**KIRKLEES METROPOLITAN COUNCIL
INVESTMENT & REGENERATION SERVICE**

**DELEGATED DECISION FOR APPLICATION FOR CERTIFICATE OF
LAWFUL DEVELOPMENT**

Reference no.: 2025/CL/91941/E

Site: Summerhill, 86, Hopton Lane, Lower Hopton,
Mirfield, WF14 8JS

PROJECT TITLE <b>SUMMERHILL</b>			
DRAWING TITLE <b>OUTBUILDING</b>			
SCALE <b>1:500</b>	DRAWN <b>EG</b>	CHECKED <b>JH</b>	PROJECT REFERENCE <b>ODS 25/985</b>
PAPER SIZE <b>A2</b>	DWG NUMBER <b>(20)001</b>	DATE <b>10/04/25</b>	REVISION <b>/</b>
CLIENT <b>MR &amp; MRS GORDON</b>

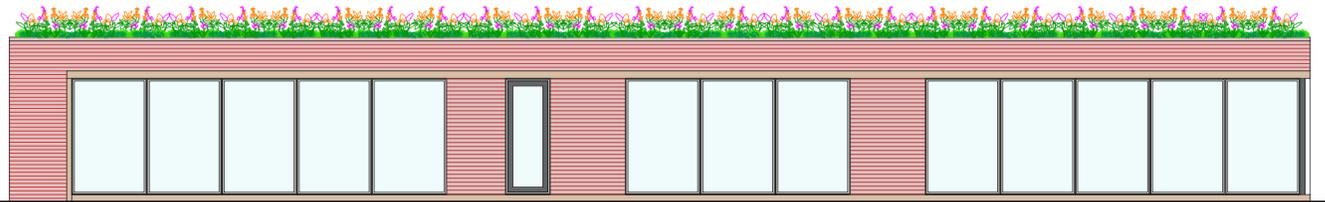
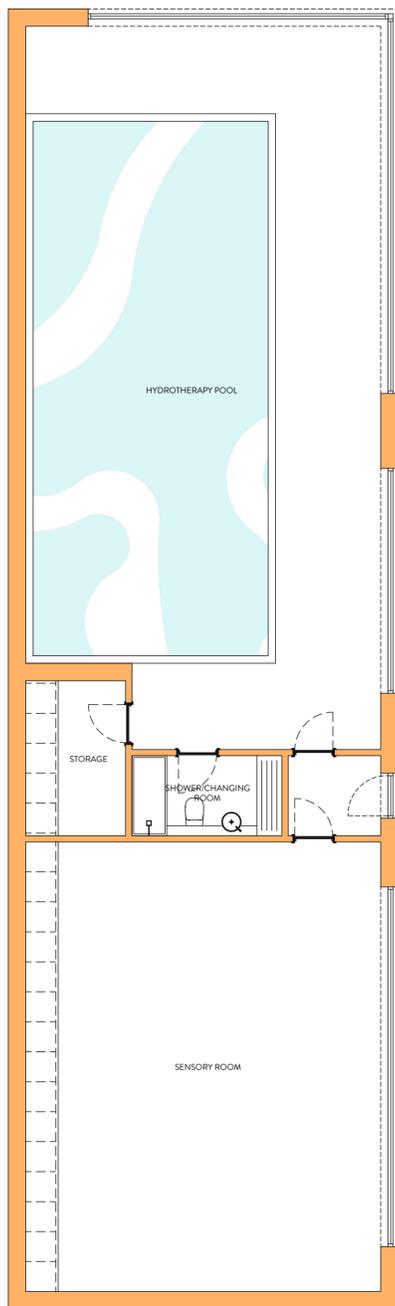
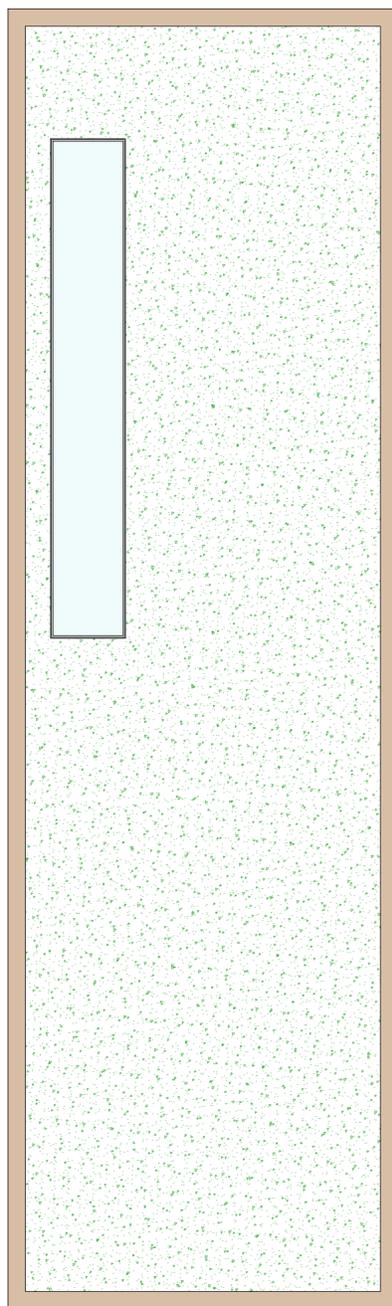
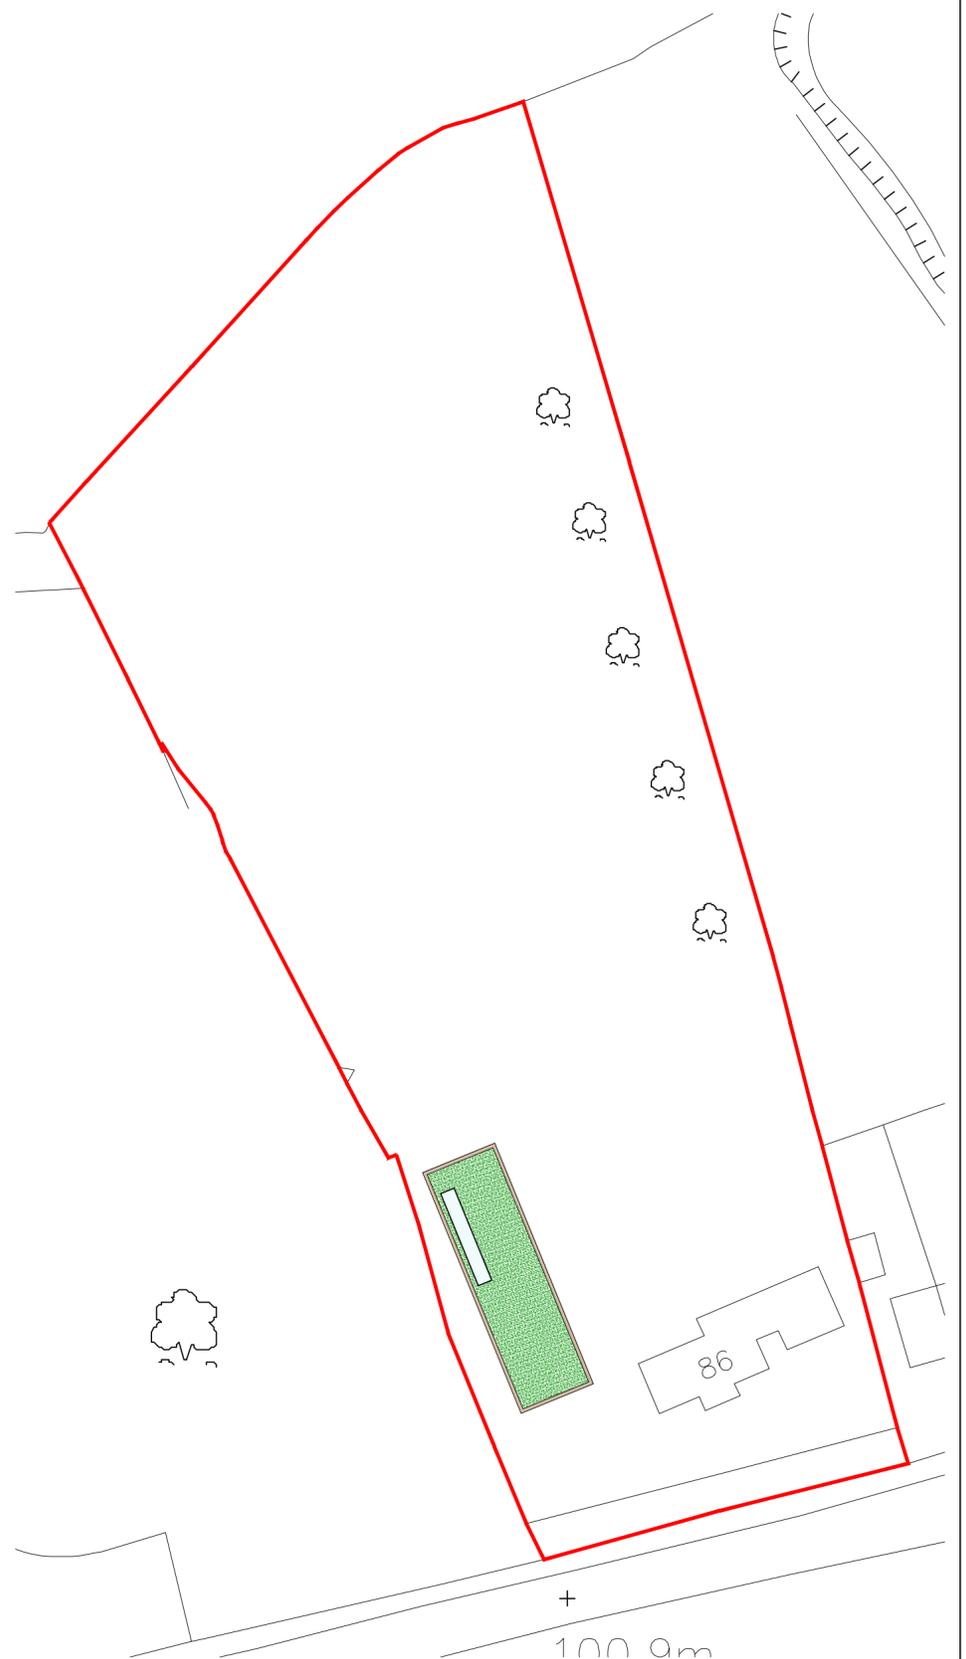
Comment: *The building would not be within 2 metres of a boundary of the curtilage of the dwellinghouse would not exceed 3 metres in height. It is noted that the building appears to have a parapet roof to accommodate the green roof therefore, it is likely, based on the information contained within the application form that the height of the roof (omitting the parapet wall) would not exceed 3 metres.*

Comment: *The overall height of the building would exceed 2.5 metres. The Permitted Development for householders Technical Guidance is clear that 'The eaves of a building will be the point where the lowest point of a roof slope, or a flat roof, meets the outside wall of the building.' Therefore, due to the overall height of the building exceeds 2.5 metres given the application form states that the maximum eaves height is 3 metres.*

Development) (England) Order 2015 (as amended), the overall size of the outbuilding is considered to go beyond that which is incidental to the enjoyment of the main dwellinghouse.

Therefore, given the size of the of the proposed building especially in terms of the increase in footprint over and above the size of the original and/or existing dwelling, it is not considered that there is any evidence to demonstrate the use of the building are reasonably necessary or required for the incidental enjoyment of the dwellinghouse.

The proposed outbuilding does not benefit from a general planning permission granted under Article 3(1) and Schedule 2, Part 1, Class E of the Town and Country Planning (General Permitted Development) (England) Order 2015 (as amended) as the eaves of the building would be more than 2.5 metres which is contrary to sub-paragraph E.1(f) of Class E.

In addition, the proposed erection of an outbuilding is not considered to benefit from a general planning permission under the provisions of Class E, Part 1 of Schedule 2 of the Town and Country Planning (General Permitted Development)(England) Order 2015 (as amended) as it has not been demonstrated the building is be required for purposes incidental to the enjoyment of the dwellinghouse.
